**Planning Application EP/23/19/HH**

**Objection to Planning Application EP/23/19/HH at 43 Sea Lane for Caravan/Car Port.**

Proposed Car/Caravan port
 43, Sea Lane , East Preston
 BN16 1NE
 Sheet 1
 Dimensions in mm
 Date- 19th February 2019
 Drawn- Paul Haymes

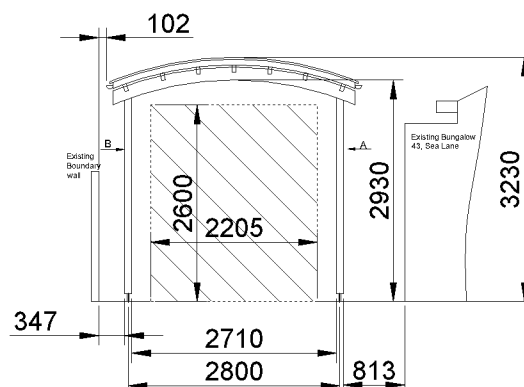
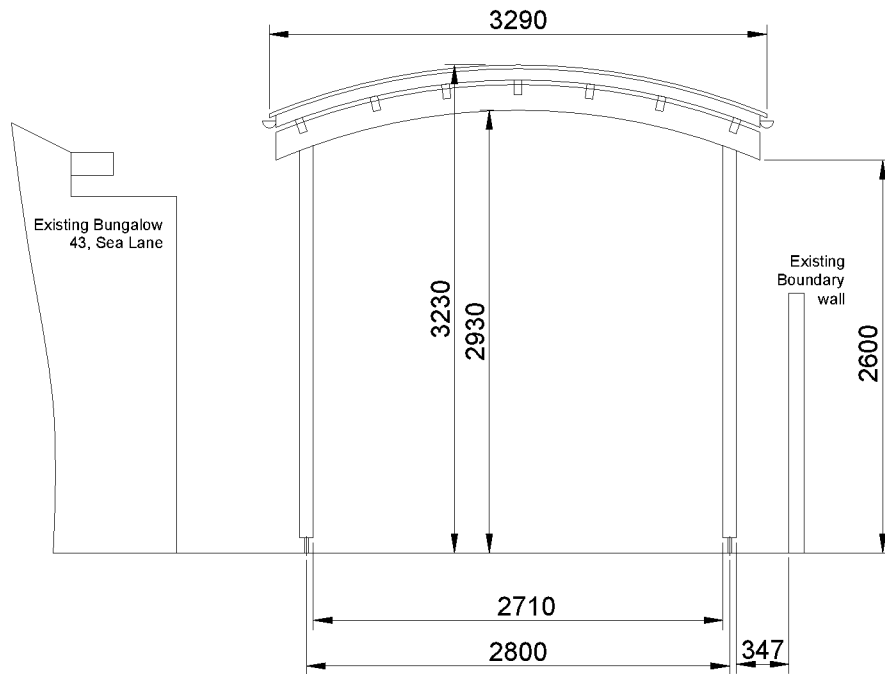
6. The proposed siting shows the pillars of the structure being too close to the party wall with 41 Sea Lane.
7. The proposed siting of the structure shows its roof edge being directly above the boundary wall between numbers 41 and 43 Sea Lane which is too close.

Proposed Car/Caravan port
 43, Sea Lane , East Preston
 BN16 1NE
 Sheet 2
 Dimensions in mm
 Date- 19th February
 Drawn- Paul Haymes

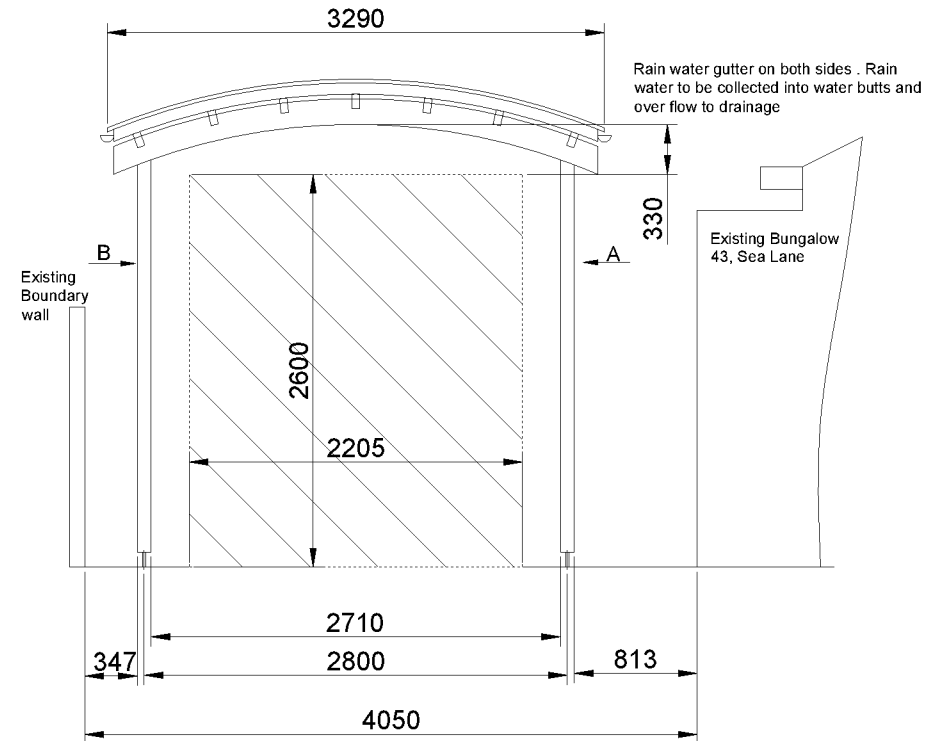
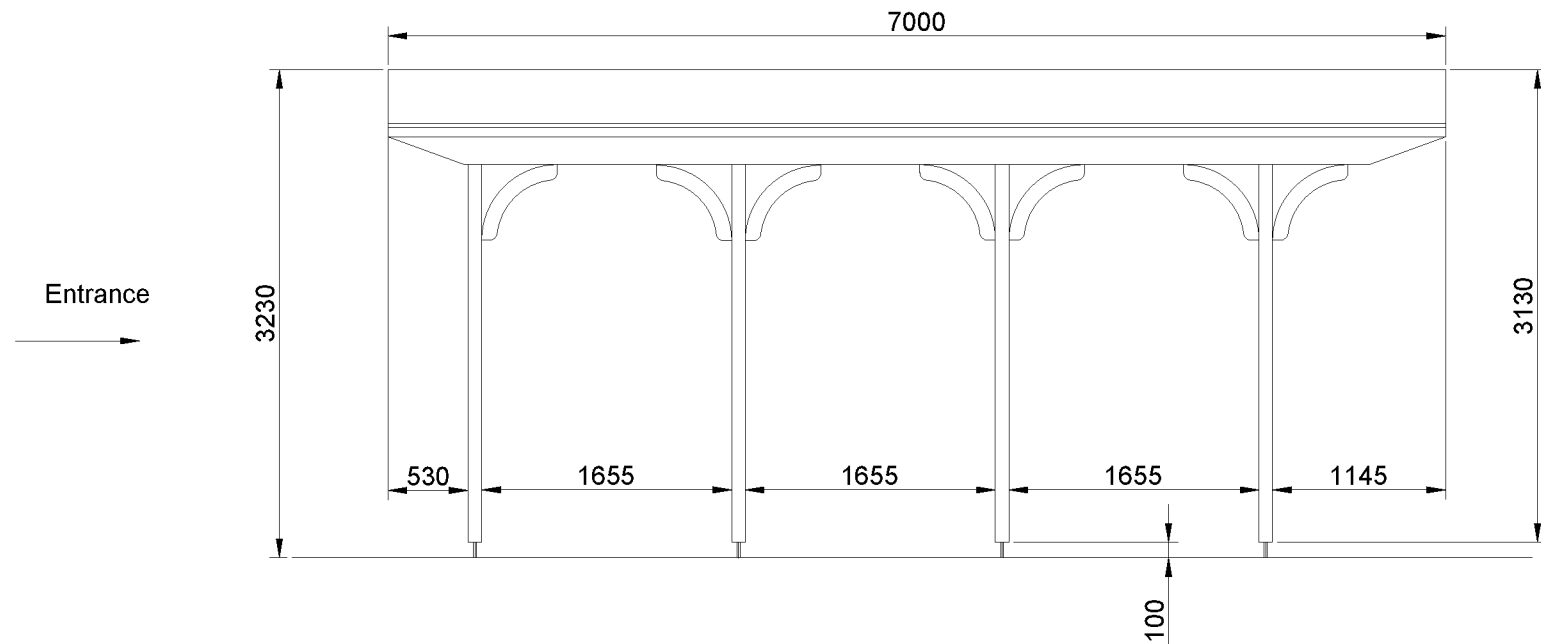
8. The proposed structure has a curved roof and any rainwater will run down directly onto the boundary wall and into the garden of 41 Sea Lane which is totally unacceptable.

9. It is not clear from the drawings of the structure whether there are gutters on either side of the roof. There is no apparent down pipe shown in the drawings so even if there are gutters there is no indication where the water will run off to. The drawings make reference to 'Jagram Tunbridge' structure and on closer inspection this does not have guttering.
10. The impact of the higher structure will have a significant loss on the level of sunlight on the area of 41 Sea Lane alongside the proposed structure and create a feeling of being hemmed in.
